Subject: **Modification Request for the Individual Section 404 and Section 10 Permits, Section 401 Water Quality Certification and CAMA Major Development Permit** for the Wilmington Bypass from US 17 in Brunswick County, north of the NC 87 intersection, to US 421 in New Hanover County. Federal Aid Project Nos. NHF-0017 (96) and STM-0017 (97), Division 3, TIP No. R-2633A&B.
Debit \$475 from WBS Element 34491.1.2

The purpose of this letter is to request modifications of the Section 404 Individual Permit, Section 10 Permit, Section 401 Water Quality Certification and CAMA Major Development Permit due to a change in jurisdictional impacts on Section A, Sites 31 and 32; and Section B Site 3 and Utility Site 2. Enclosed are revised Section A Permit Drawings 7, 8, 90, 91, 92, 93, 94 and 95 of 108, Section B Permit Drawings 2, 3 and 73 of 73 and Utility Drawings 3 and 15 of 15.

Utility Permit Drawing  
Sheet 3 of 15  
Revised 4/22/14

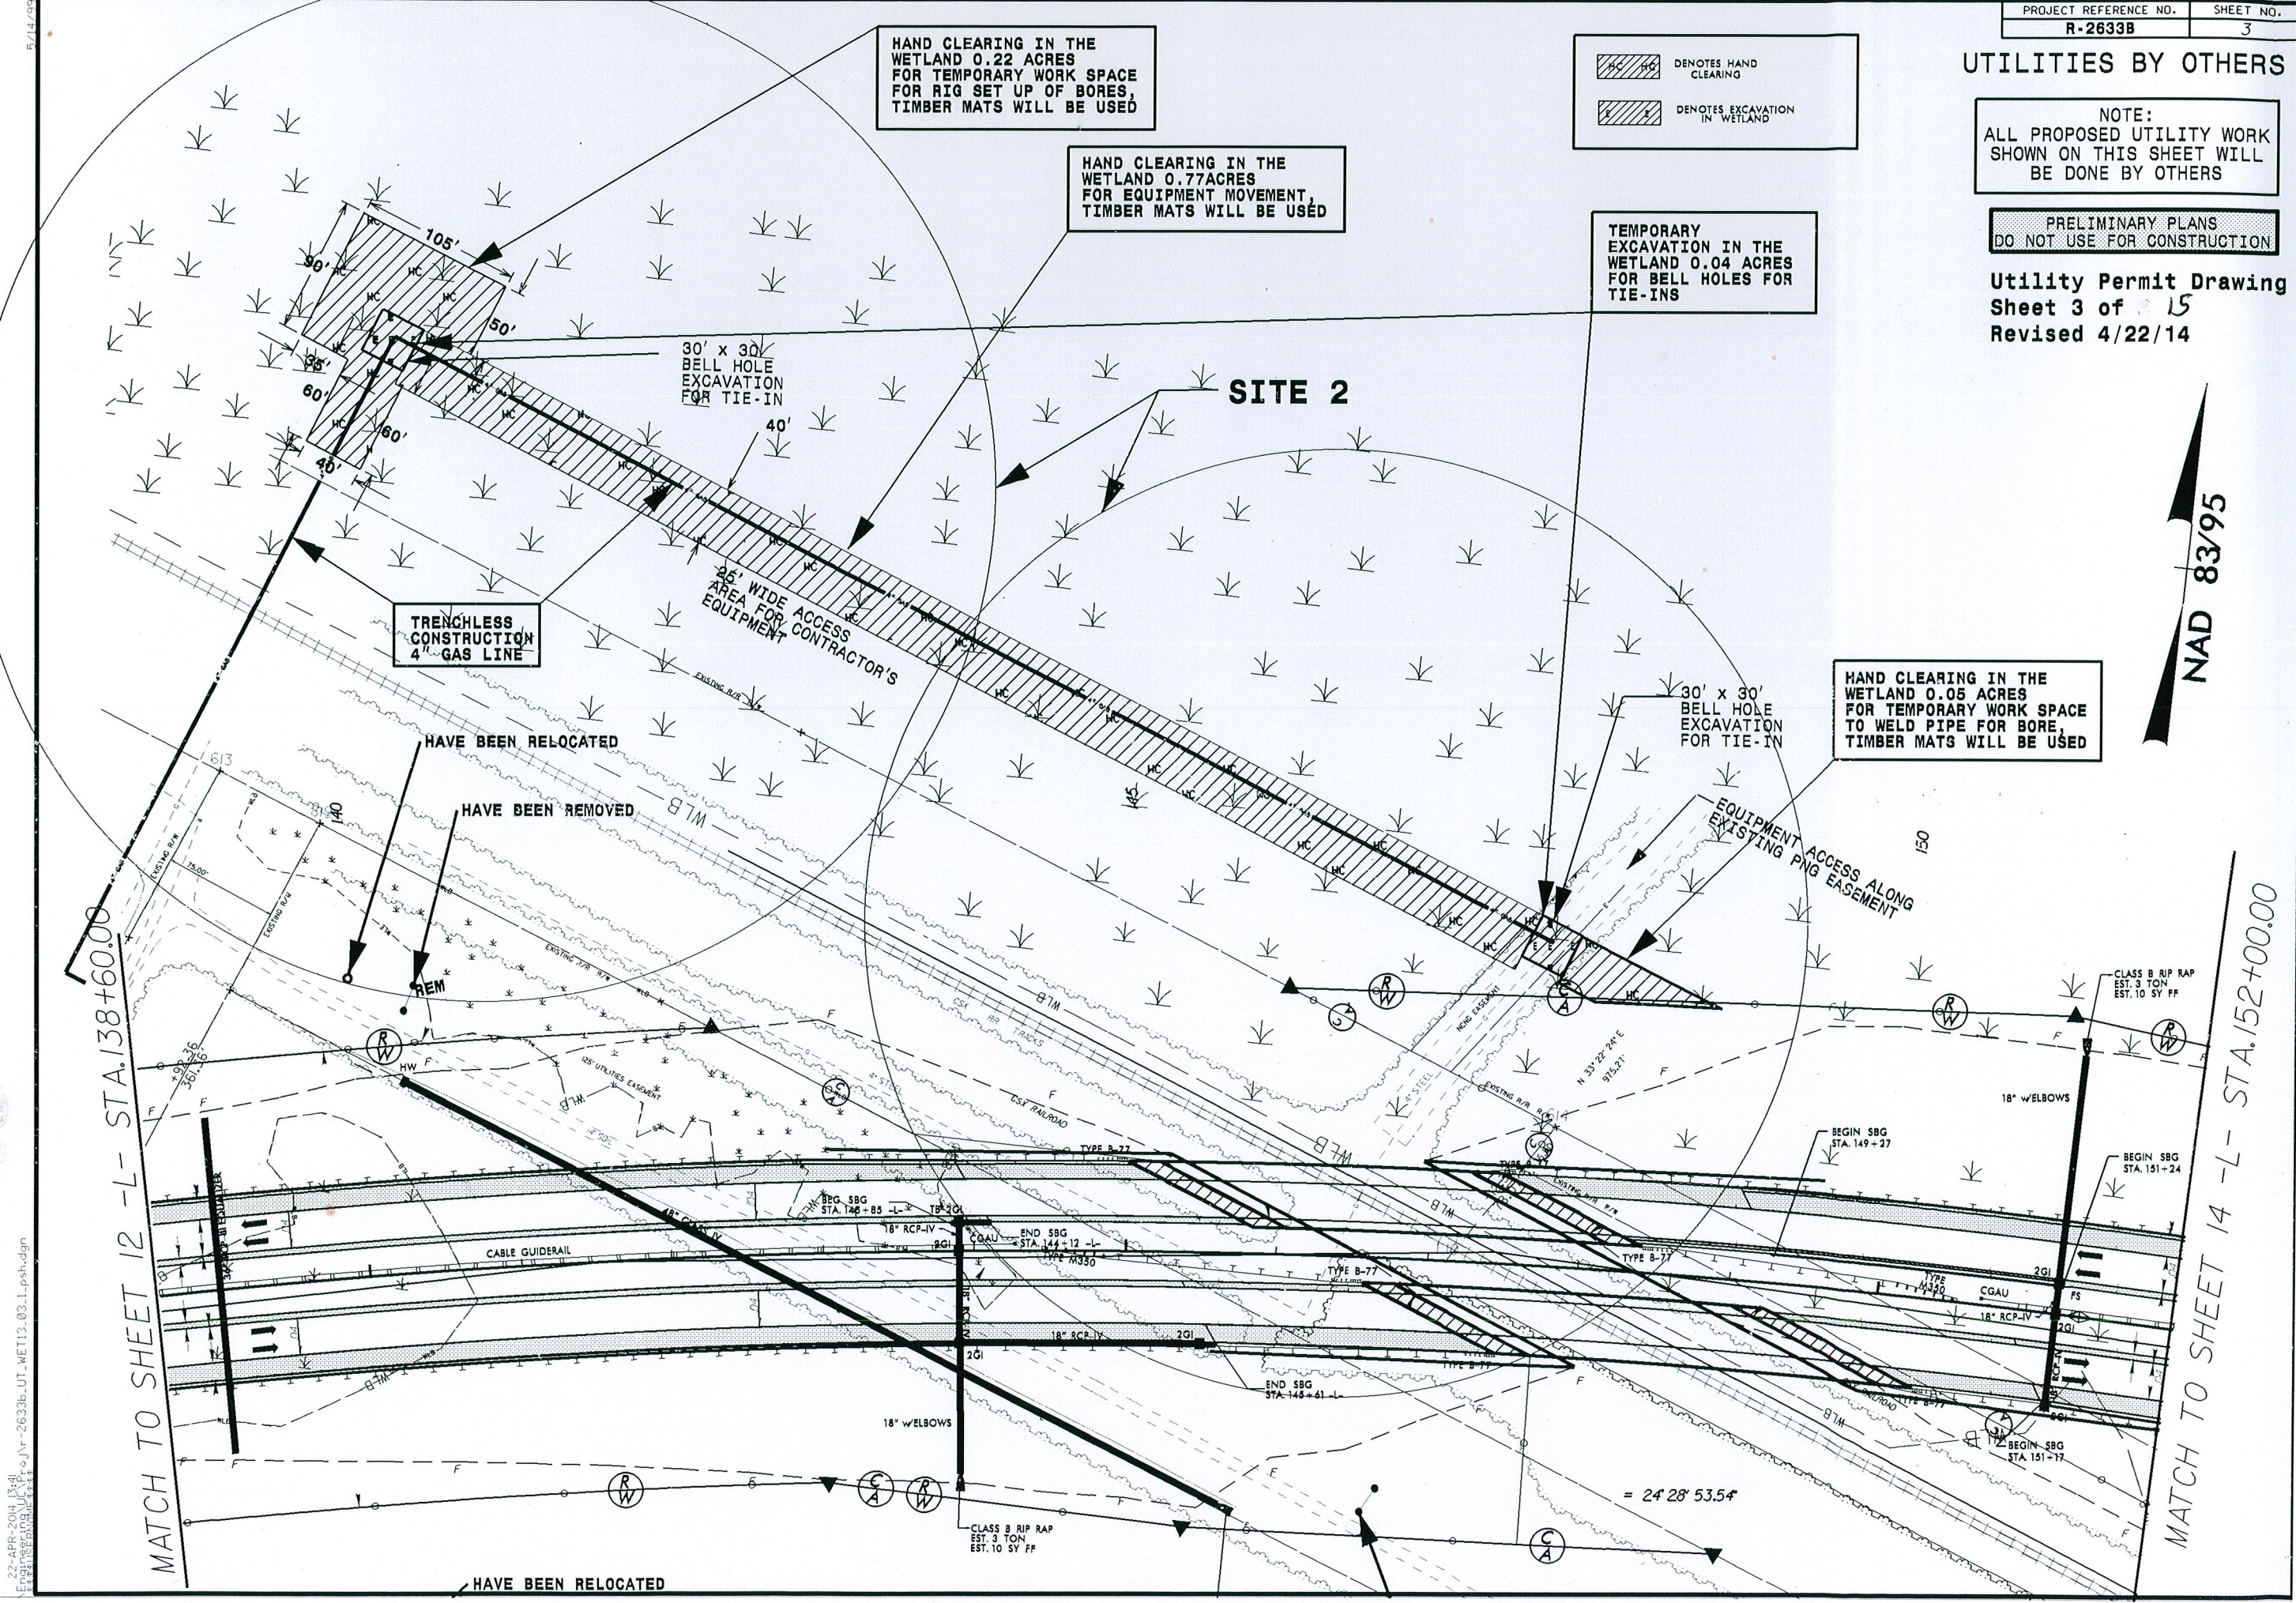
The only change to this site is an overall decrease in hand clearing. The contractor needed less room for staging near Station -L-140+00 but increased the width of the hand clearing 40 feet along the length of the pipe for equipment moving. Total net decrease in hand clearing is 0.32 acre for a total of 1.19 acres of hand clearing.
